Online Comment

Application H16-0790-21
Location 32-33 Hall Place Spalding PE11 1SG
Proposal Proposed Signage

Name Greg Watkinson
Address Conservation Officer

DESCRIPTION
EXISTING & PROPOSED SHOPFRONT
ELEVATION

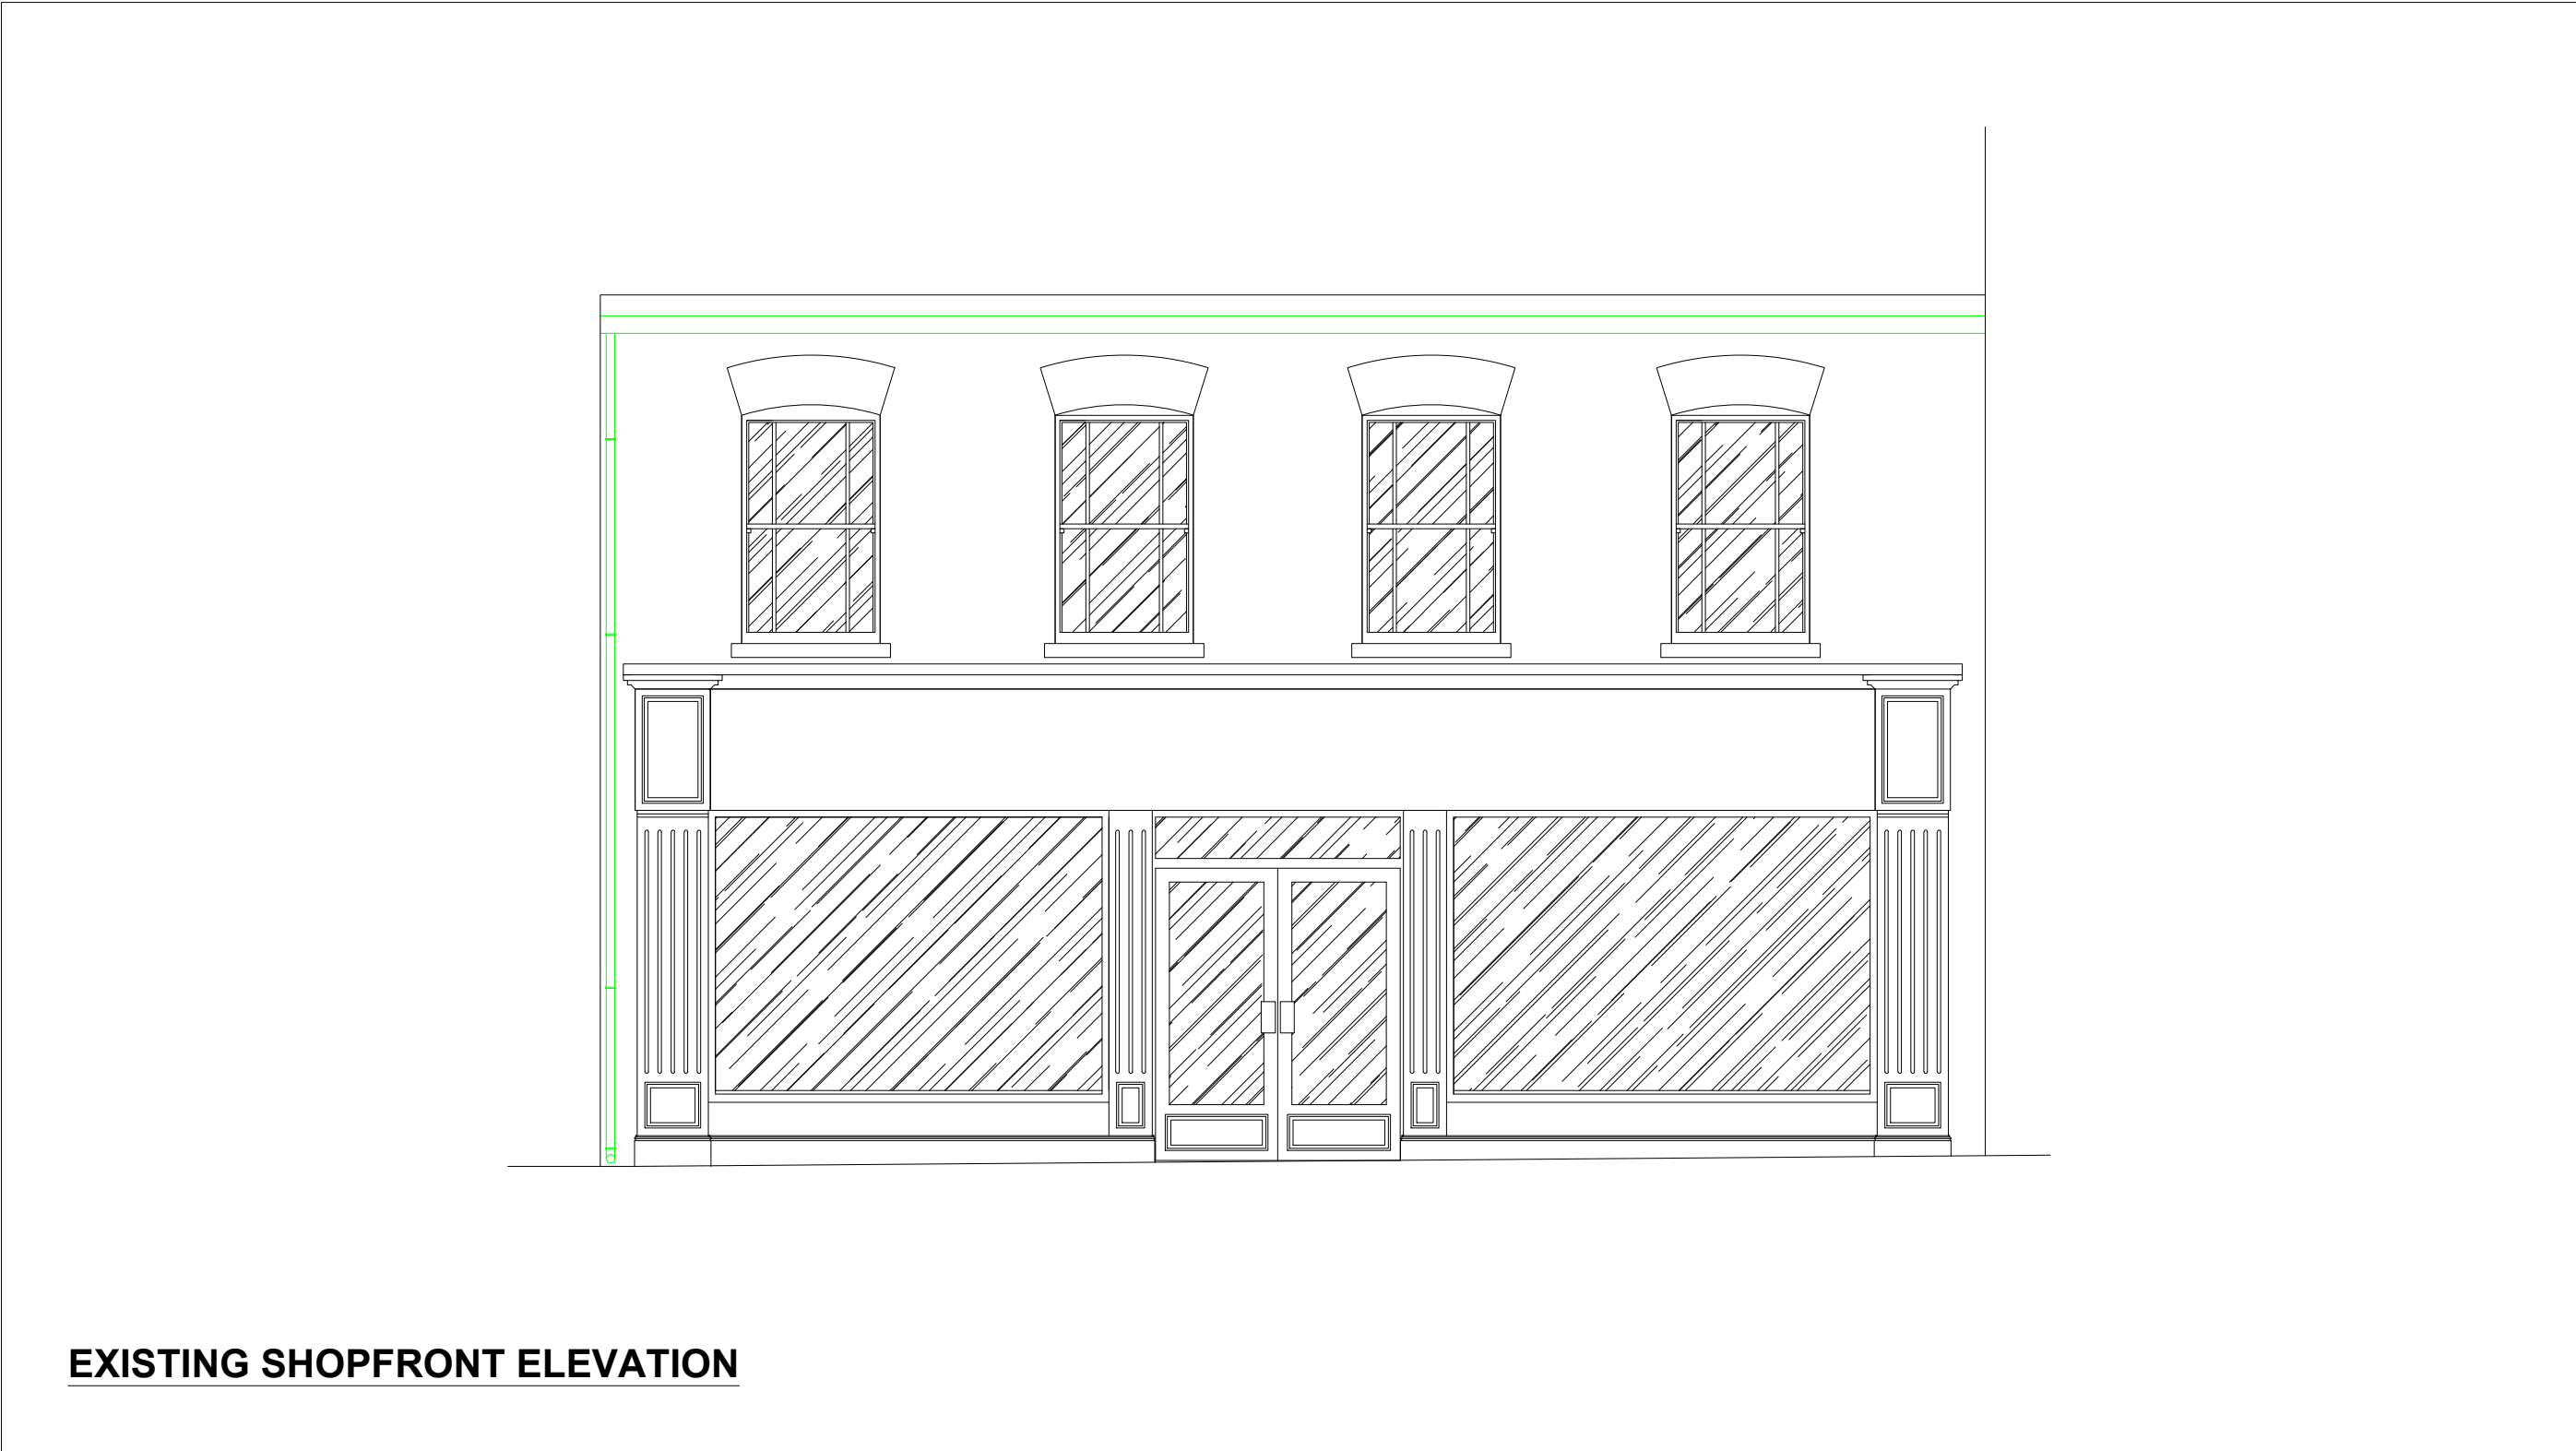
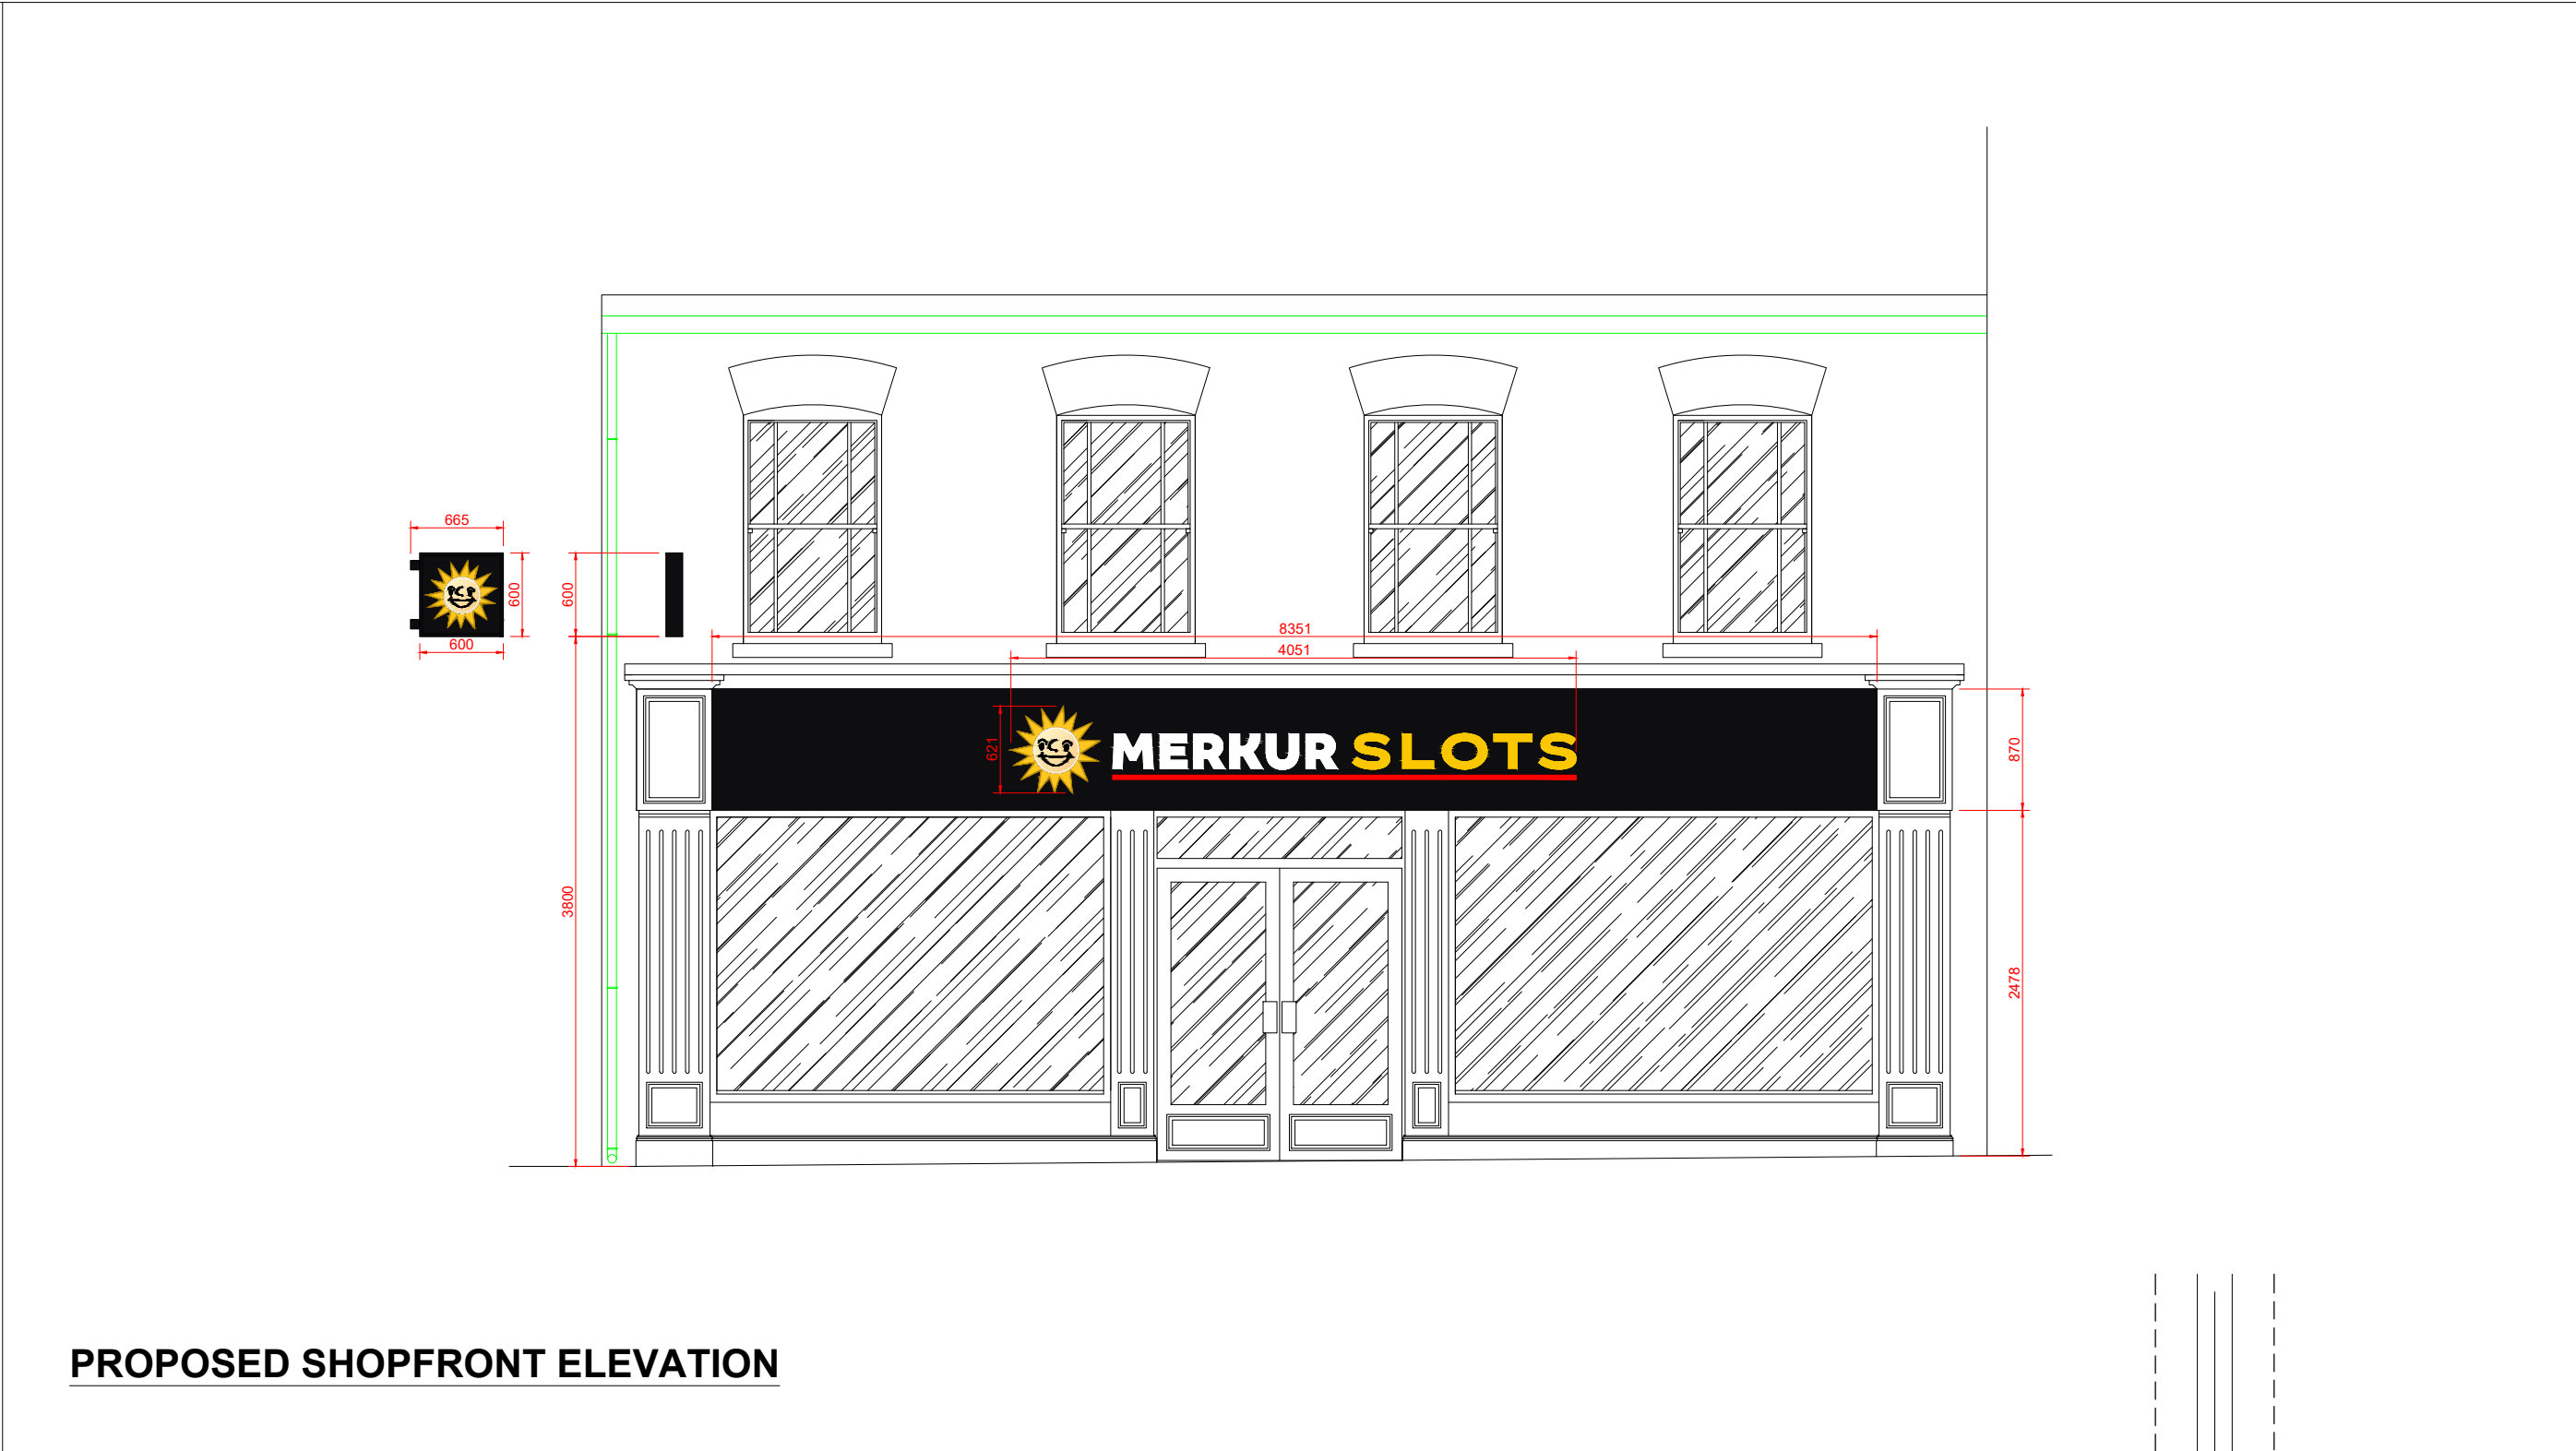
From a Conservation perspective, I do not feel that the proposed signage is appropriate in design and construction for the Conservation Area setting, especially in such a prominent portion of the primary shopping area of Spalding.

The proposed restoration of the pilaster details and the avoidance of direct application vinyl is appreciated. However, I believe that cumulatively, the modern, somewhat characterless design of the signage and the bold, bright colour scheme (notwithstanding the black background) are at odds with the aims of Policy 29 of the South East Lincolnshire Local Plan, in that they do nothing to assist in the enhancement of the character and distinctiveness of the Spalding townscape. A more carefully considered, heritage focussed proposal, that was commensurate with the Conservation Area would be far more preferable.

Additionally, I note that it is proposed that the signage would be internally illuminated, which is again, at odds with the standard of the conservation area. Apart from in exceptional circumstances, internally illuminated signage is not generally considered to be appropriate for signage in a conservation area owing to the fact that it completely alters and modernises the character of a townscape, especially at night. As such, I would suggest that any successful proposal should only include external illumination methods.
